Reference No:	2022/62/93750/W
Site Address:	479, New Hey Road, Salendine Nook, Huddersfield, HD3 3XG
Description:	Erection of a rear dormer and a single storey rear & side extension with disabled ramp.
Recommending Officer:	Sam Jackman

DECISION – Conditional Full Permission

Officer Report – 2022/93750

Drawing Title:
Proposed Elevations

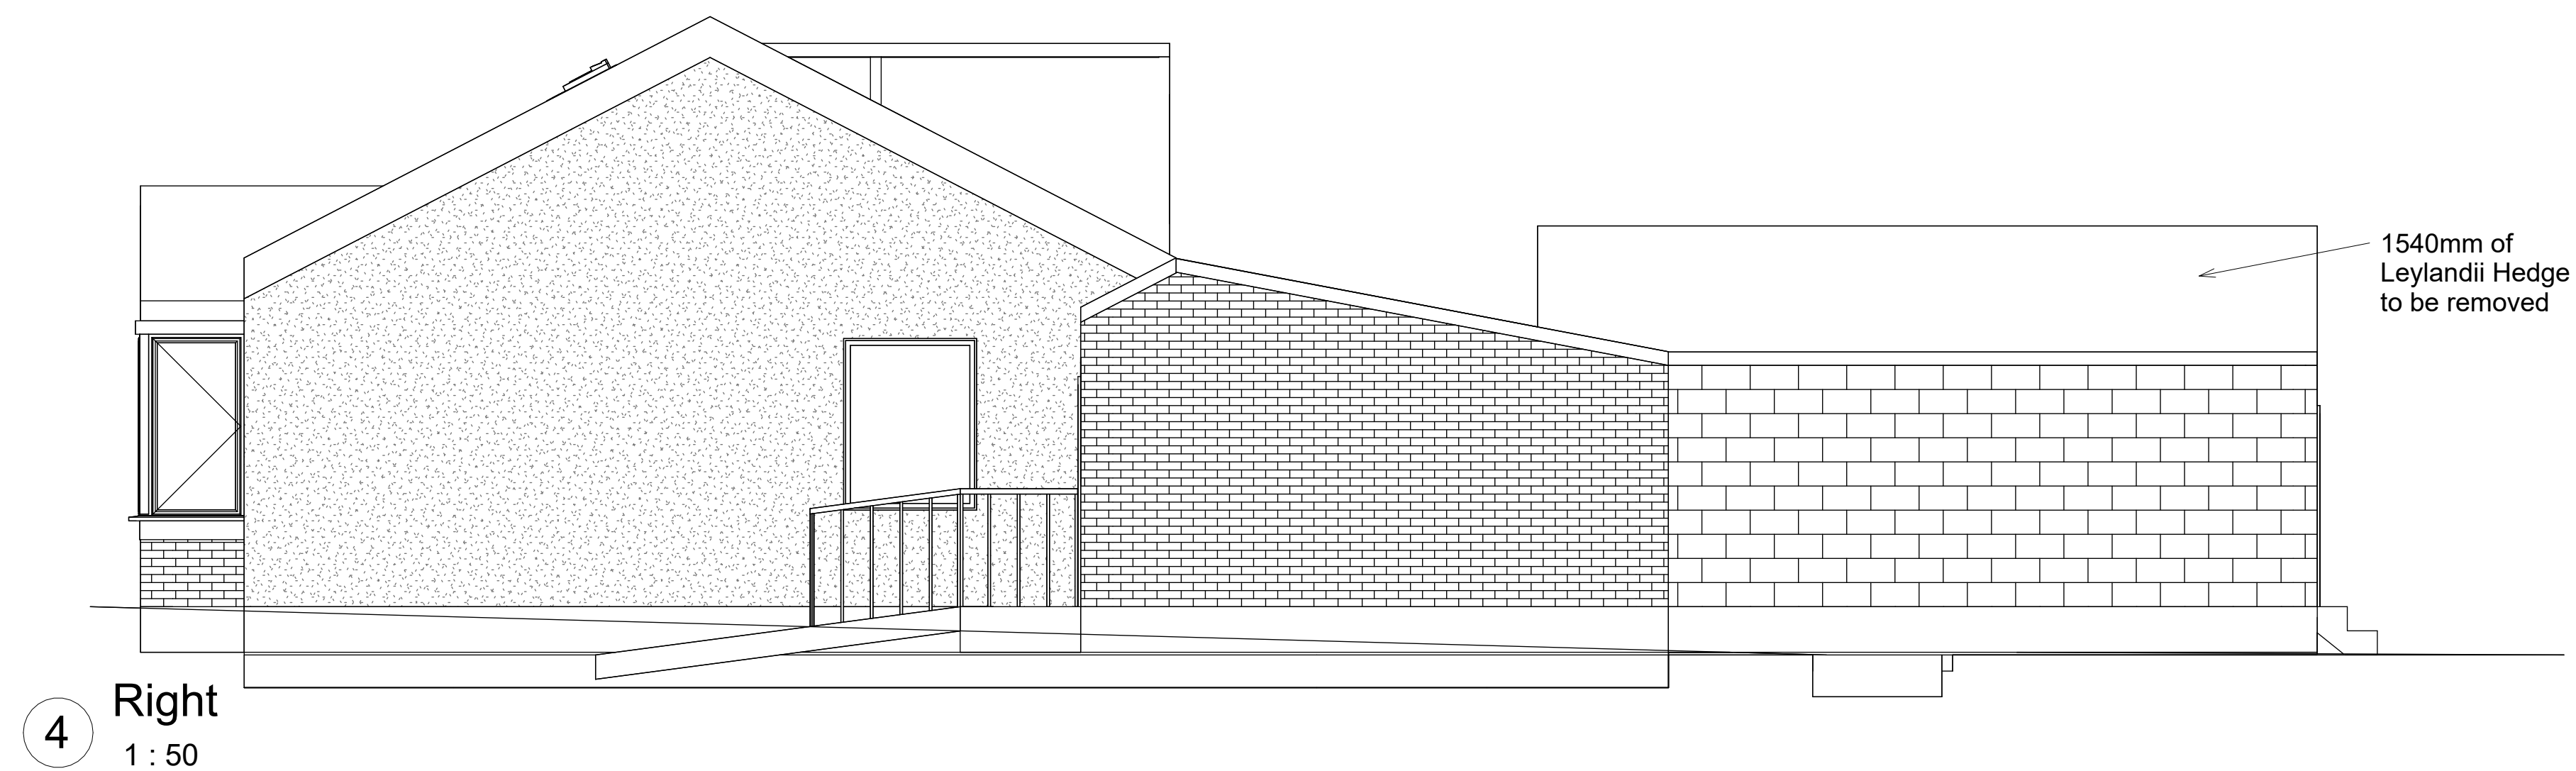
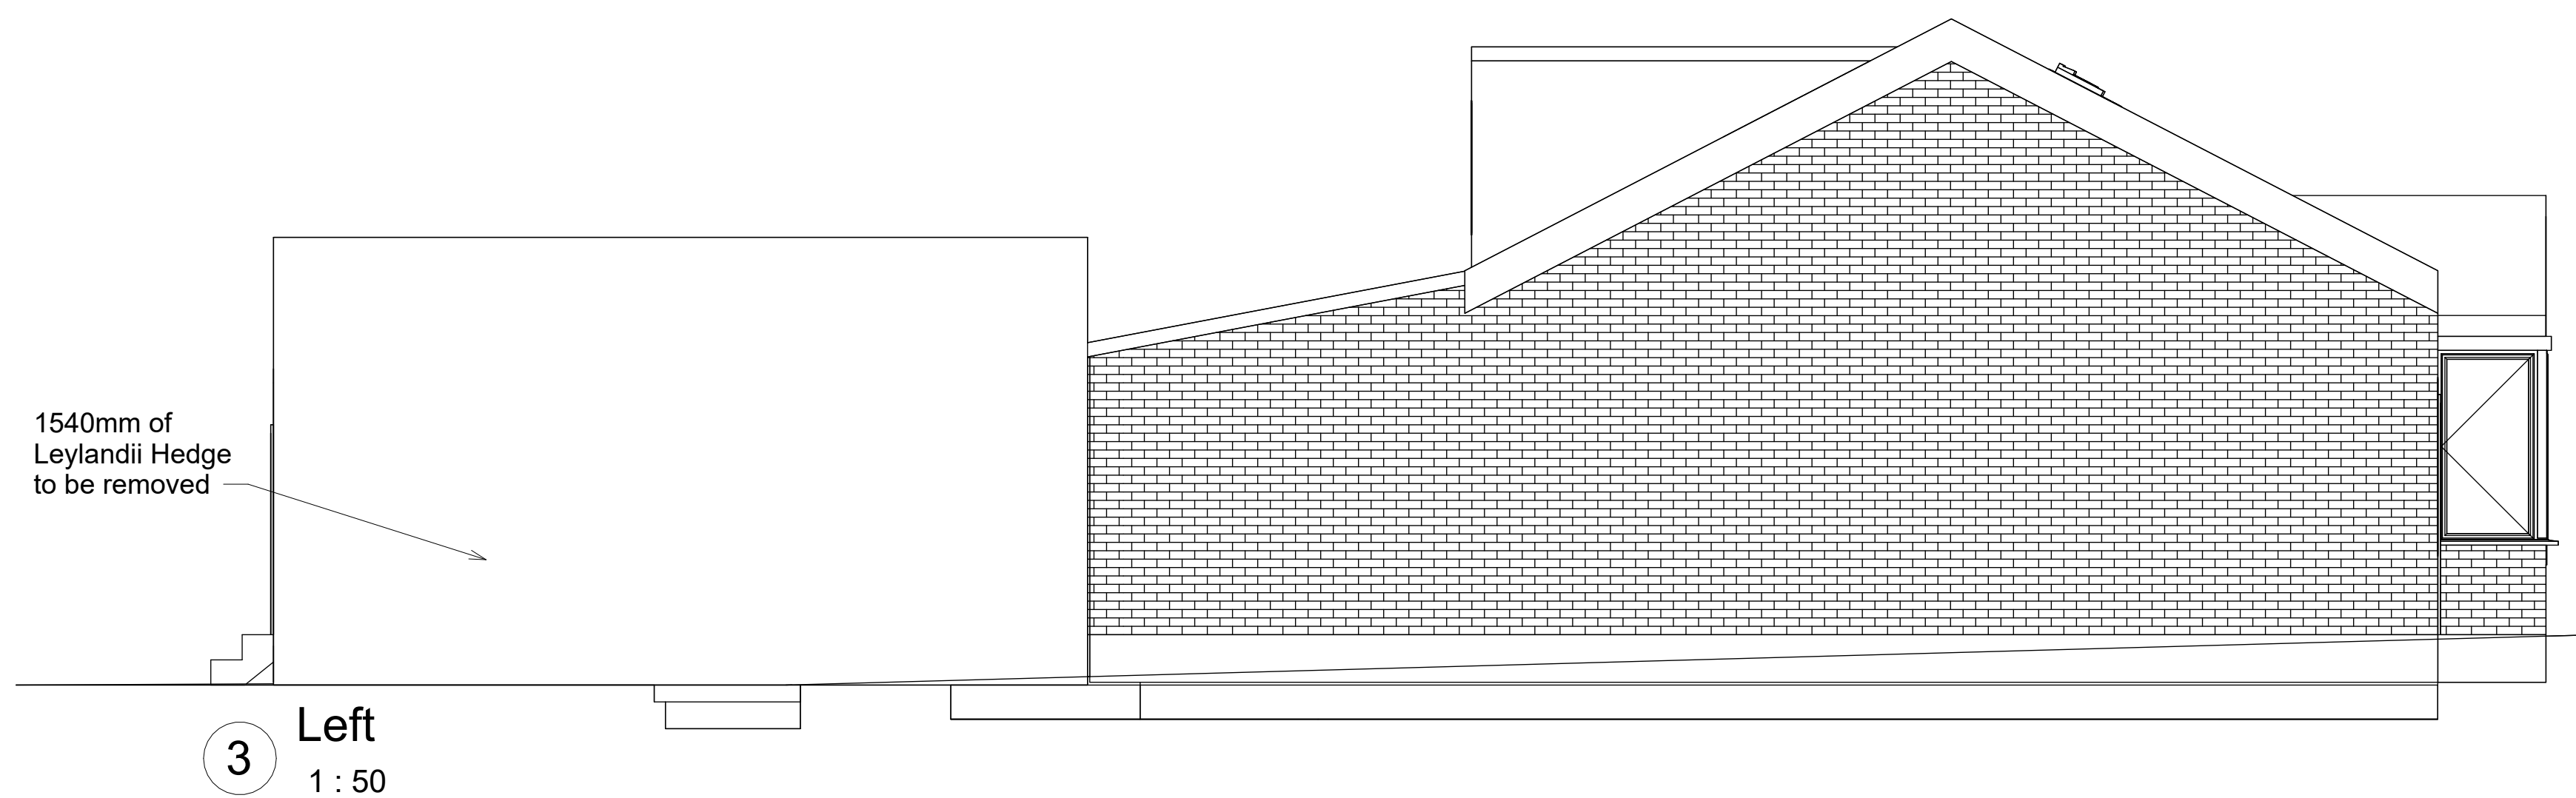
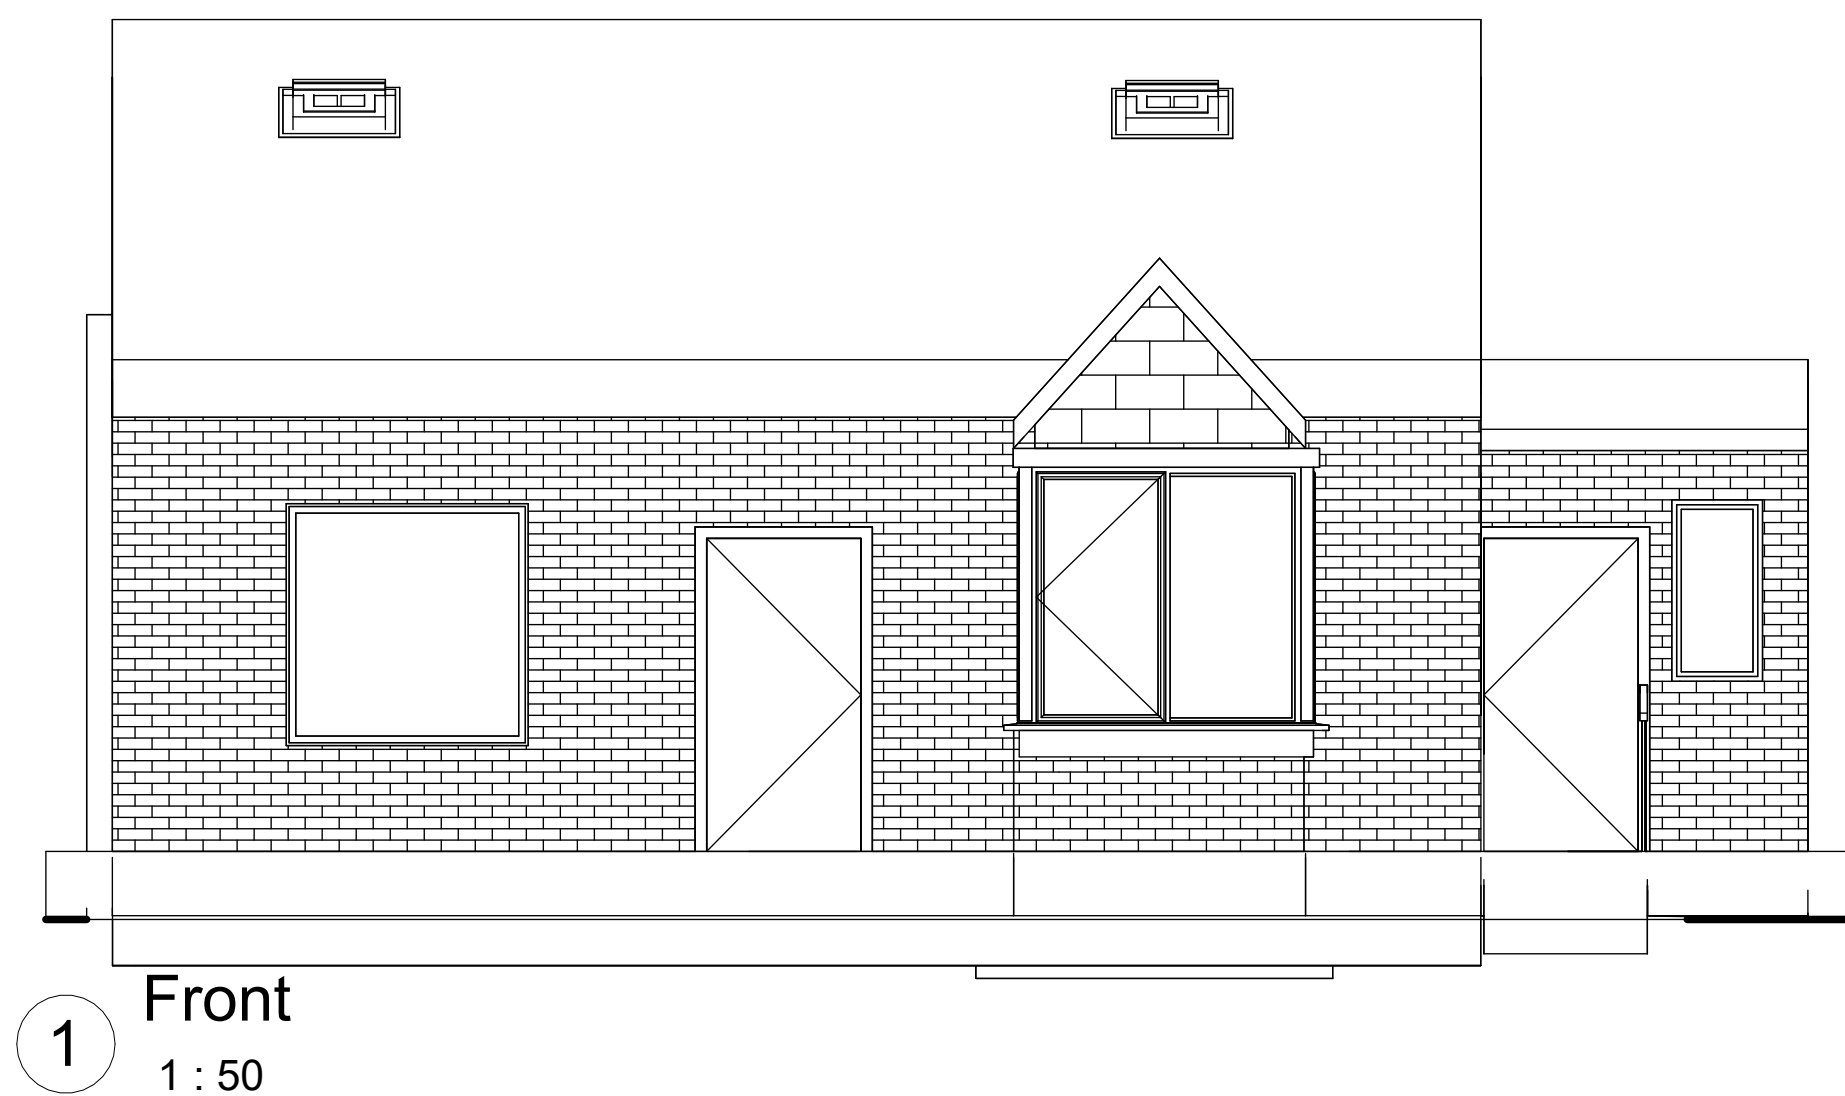
Section 5.25 goes on to state the design of dormer windows and roof extensions should reflect the character of the area, the surrounding buildings and the age, appearance and materials of the existing house. Where in this case the dormer is fairly large having an overall width of 7.85m, however, the dormer will be set in from the gable and shared party wall by 0.5m, in addition to be set down from the ridge by 0.25m. Furthermore there are a couple of properties along New Hey Road which have had similar sized dormers. Therefore, provided the dormer sides are dark hung tiles (condition 4) the dormer would have an acceptable design.

Where in this case the rear extension would fail points 3, 4 & 5, however, in this case consideration is firstly given to the fact that the extension in part is for specific needs and secondly the neighbour has also applied for a similar sized extension in the form of a rear extension and dormer. It should also be noted that the current boundary treatment is in the form of a leylandii hedge of approx. 4m high, which will be removed for the first 1.54m as part of this application, which in itself overshadows and dominates the rear garden. Therefore, on balance the proposal would be acceptable with regards to the SPD.

In this case the extension wouldn't be more than two thirds of the width of the original house, it would be set back from the front elevation by 7m with an overall height of 3.65m and albeit designed with the eaves high having the appearance of a small lean-to roof is acceptable, therefore, on balance would be acceptable in regards to the SPD.

4. Notwithstanding the submitted details, the rear dormer shall be clad in a suitable dark grey cladding or tile hung to match the existing roof and should be retained as such for the lifetime of the development.
